16 December 2010

Re: Bungarribee Industrial Estate – Metcash Distribution Centre and Offices (MP 10_0140) – response to submissions

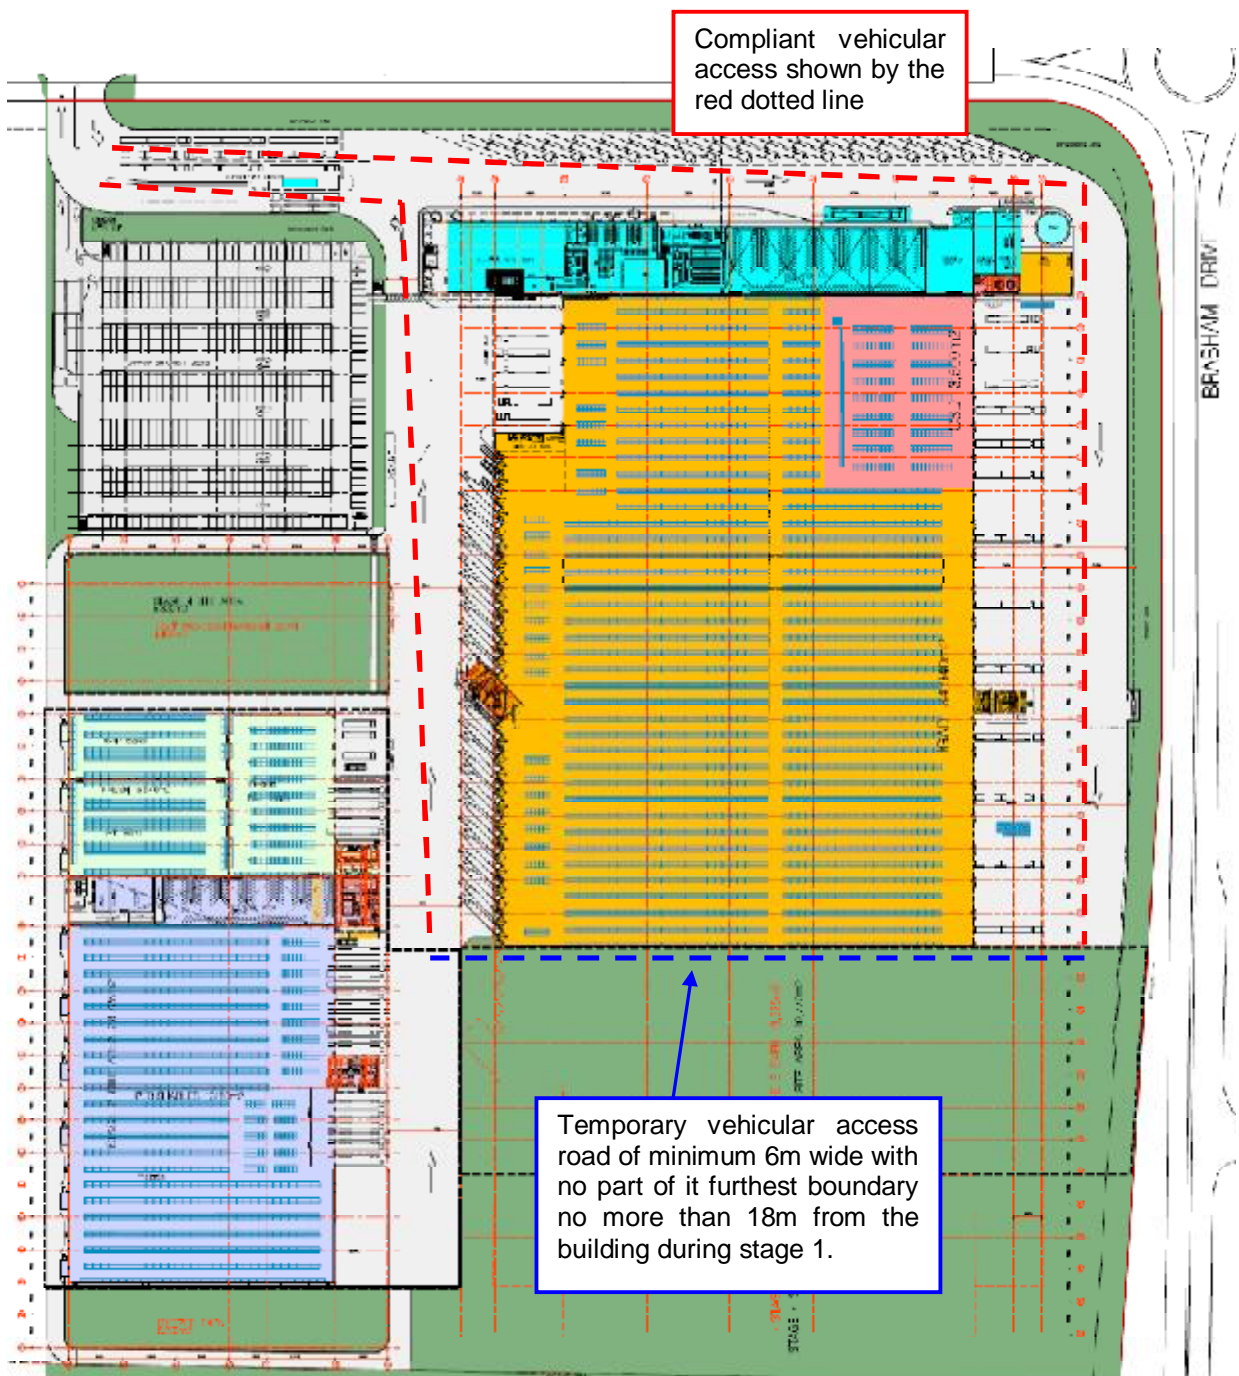
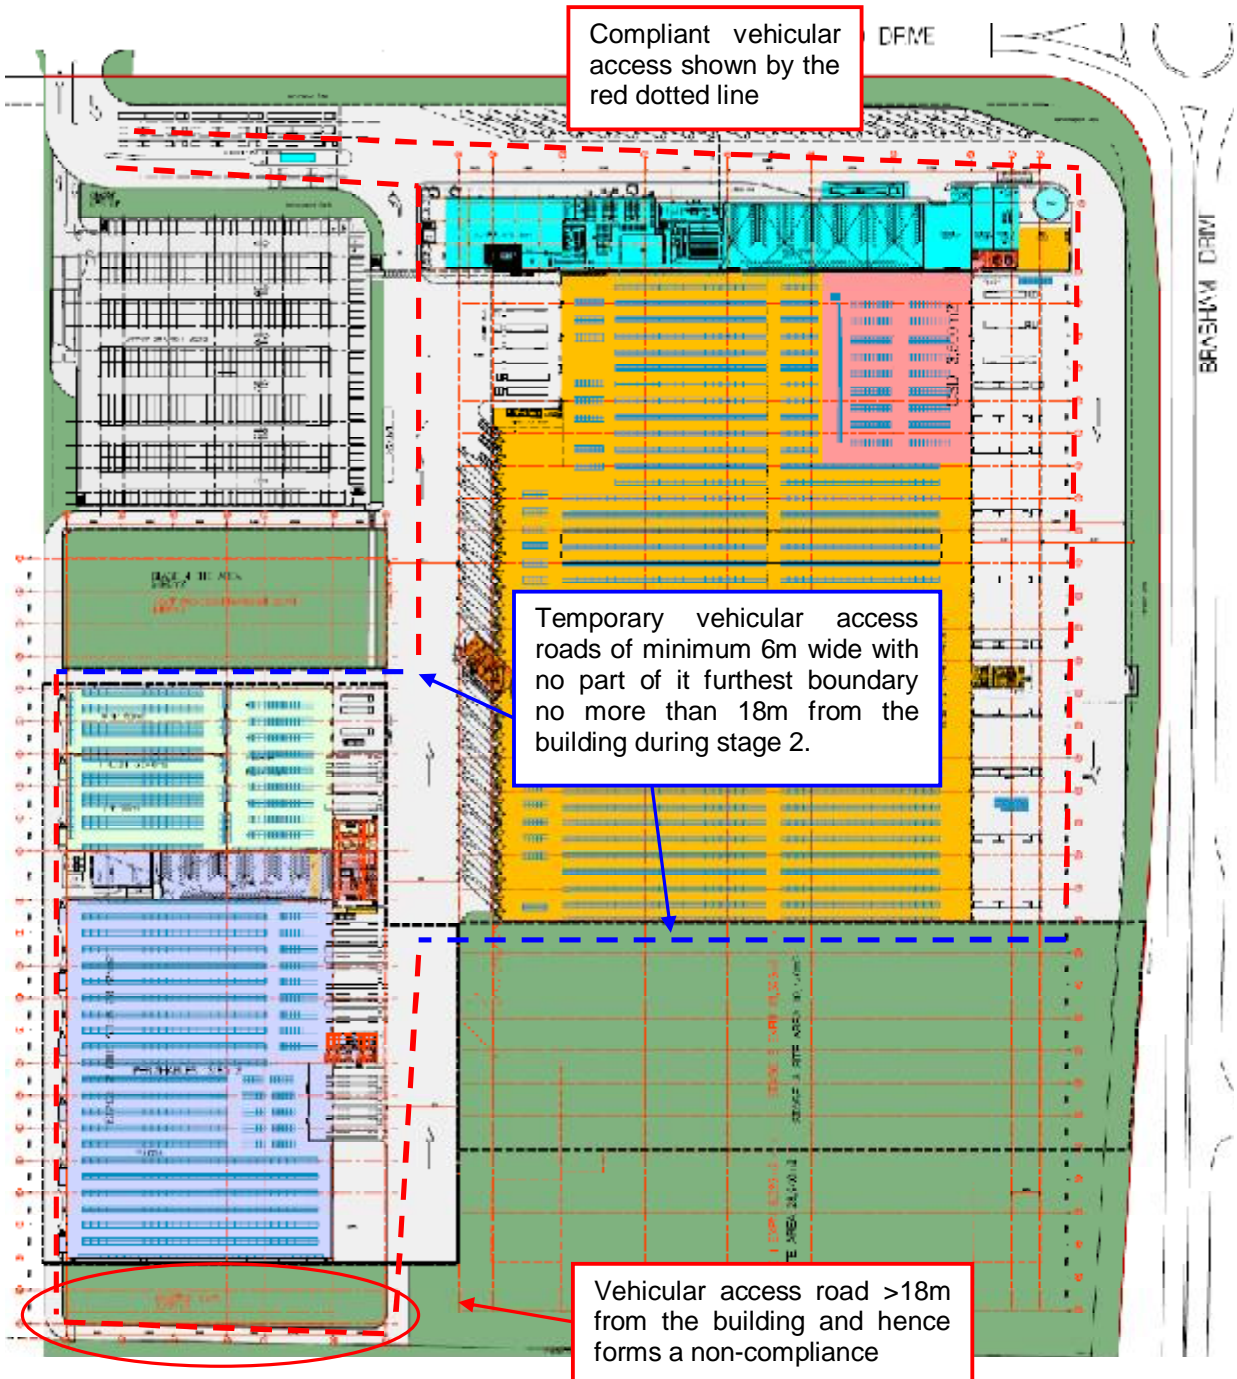
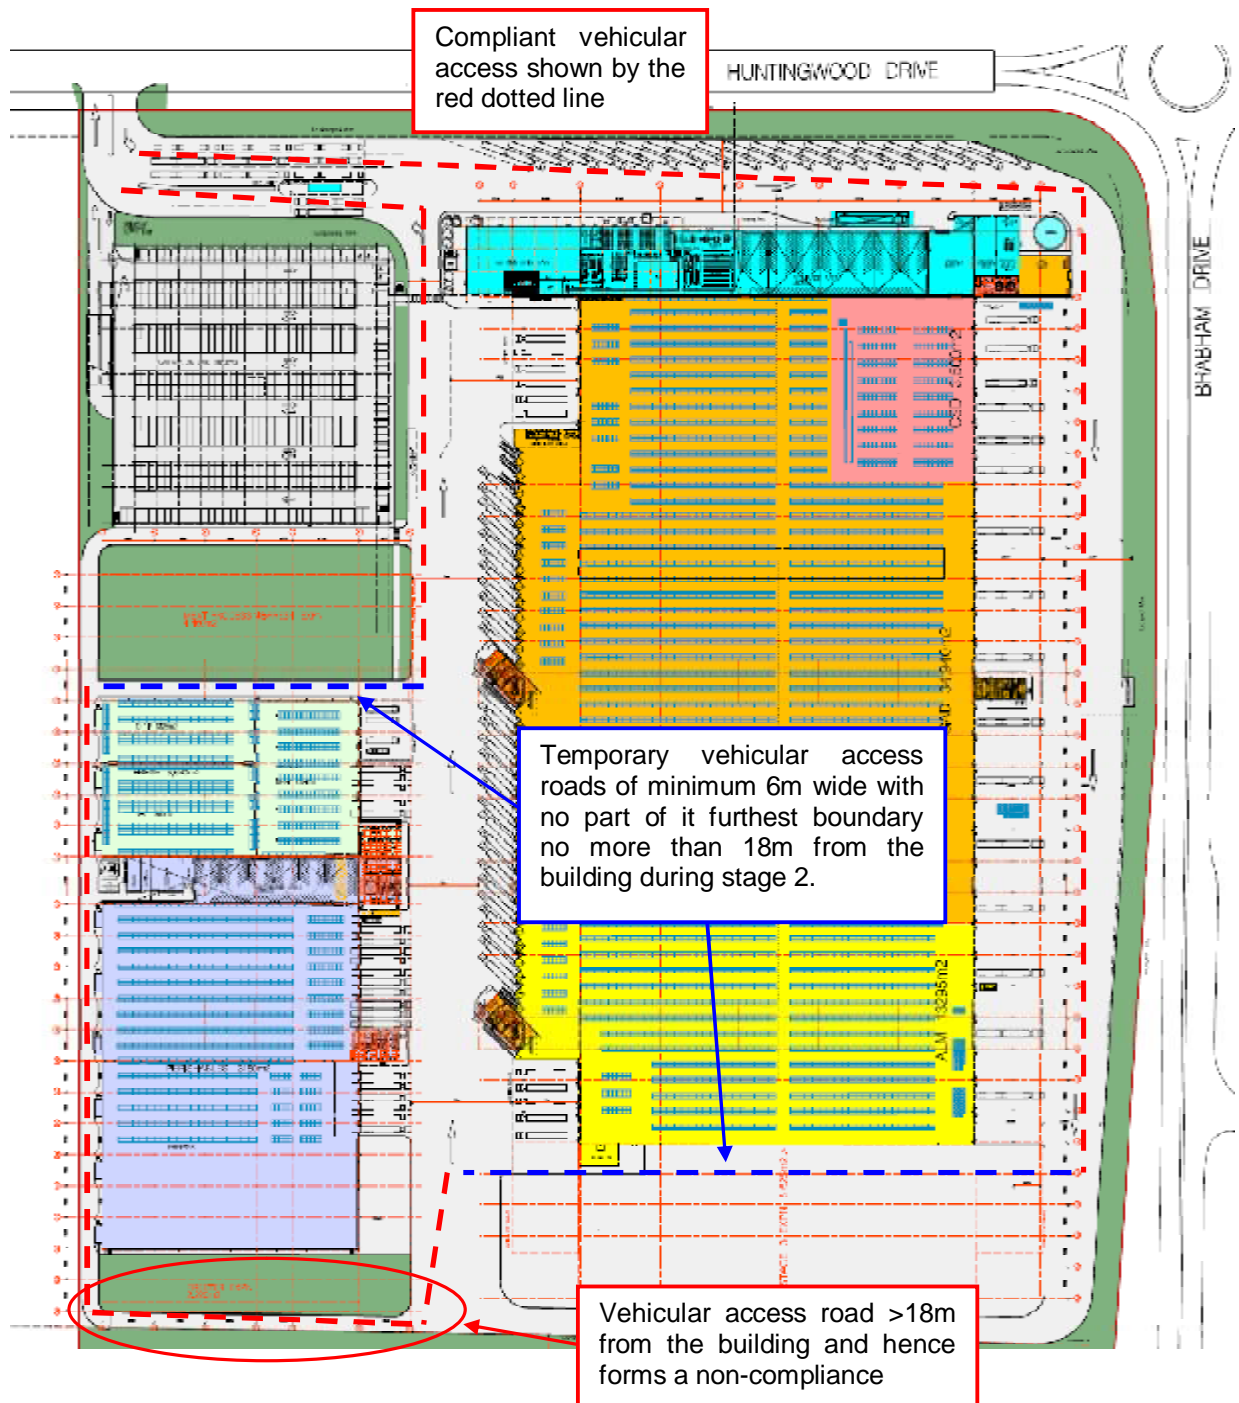
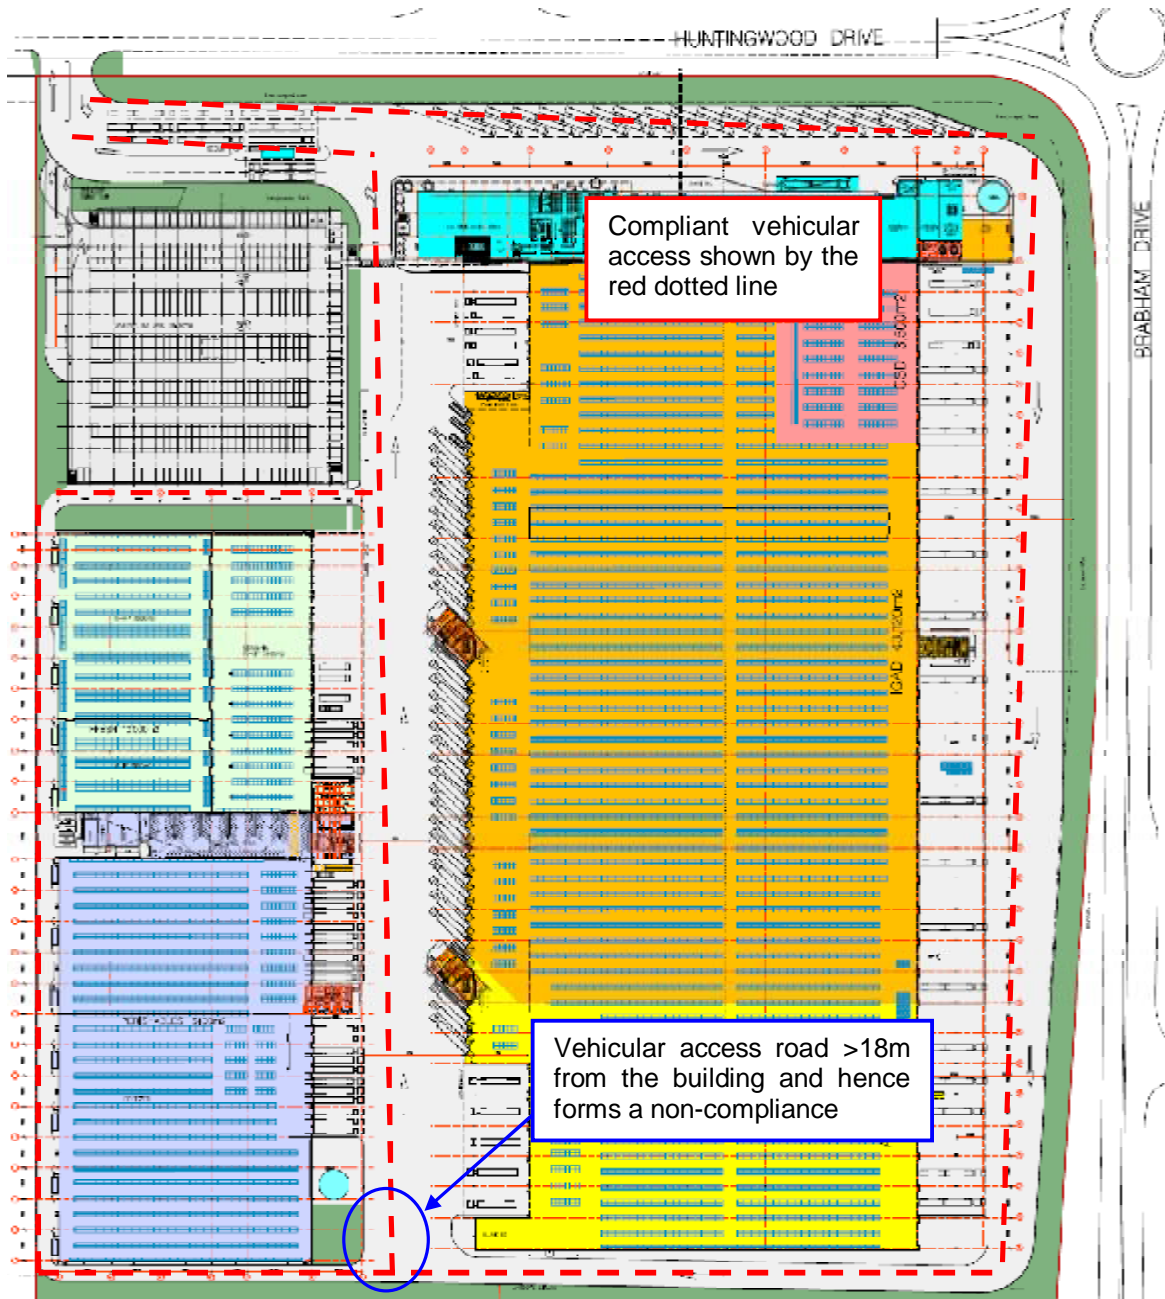
(i) The proposal showed a shared driveway for both heavy and light vehicles to the western boundary of the site. The shared driveway is not supported as there is a conflict between trucks and cars near the car park entry ramp. It is our view that driveways must be separated to avoid conflicts between heavy and light vehicles. This could be achieved by providing truck access as part of the precinct plan roundabout between Lots 2, 3, 4 and 6 and retaining the western access point for cars only.	
(ii) It is noted with concern that the proposal suggested the deletion of the precinct plan	(ii) A Traffic Volume Assessment and Road Safety Review has been carried out as

(1) To eliminate vehicle conflicts between bicycles, light and heavy vehicles at the entry/exit to the site, the Department should consider requesting the applicant to redesign the entry/exit to separate heavy and light vehicles. This could be achieved by providing separate driveways for the car parking area and the heavy vehicle access.

<i>Issues Raised</i>	<i>Goodman Response</i>
1. Traffic	
Traffic section has raised some issues with respect to the internal driveways, particularly;	(i) The response to these issues is clearly detailed in the Halcrow letter dated 8 December 2010 (see Attachment 1.0). The proposed shared truck and car access is based on an existing Metcash facility in Laverton and operates successfully. It also has the benefit of increasing potential for off-street queuing. We have had this arrangement reviewed and tested by Halcrow who have confirmed that it is capable of operating safely and effectively.

(1) The response to these issues is clearly detailed in the Halcrow letter dated 9 December 2010 (see Annexure 3.0). The proposed shared truck and car access is based on an existing Metcash facility in Laverton and operates successfully. It also has the benefit of increasing potential for off-street queuing. We have had arrangement reviewed and tested by Halcrow who have confirmed that it is capable of operating safely and effectively.

The potential of conflict between heavy and light vehicles near the car park entry ramp was considered during the design process. The more detailed proposal, which is not shown clearly on the submitted masterplan, involves a scheme to manage traffic priority at this location by means of give way intersection controls as shown on the sketch below.

The proposed layout will have the following features

- The location of the driveway relative to the gatehouse allows for a large number of B-doubles to park prior to the gatehouse, which gets them off the street network thereby not blocking cars wishing to enter the site / car park (*as is the case on other entrances on Huntingwood Drive to the east*)

- Trucks will be leaving the gatehouse via boom gates and then travelling at low speed before stopping at the Give Way line further west.
- The boom gates will not allow a continuous chain of B-Doubles exiting the gatehouse which means that cars will find adequate gaps to emerge from the car park.

- Cars leaving the car park will also be required to give way. They will need to give way when trucks are emerging from their Give Way line. This truck movement will be at low speed and therefore should not result in any adverse safety conditions.
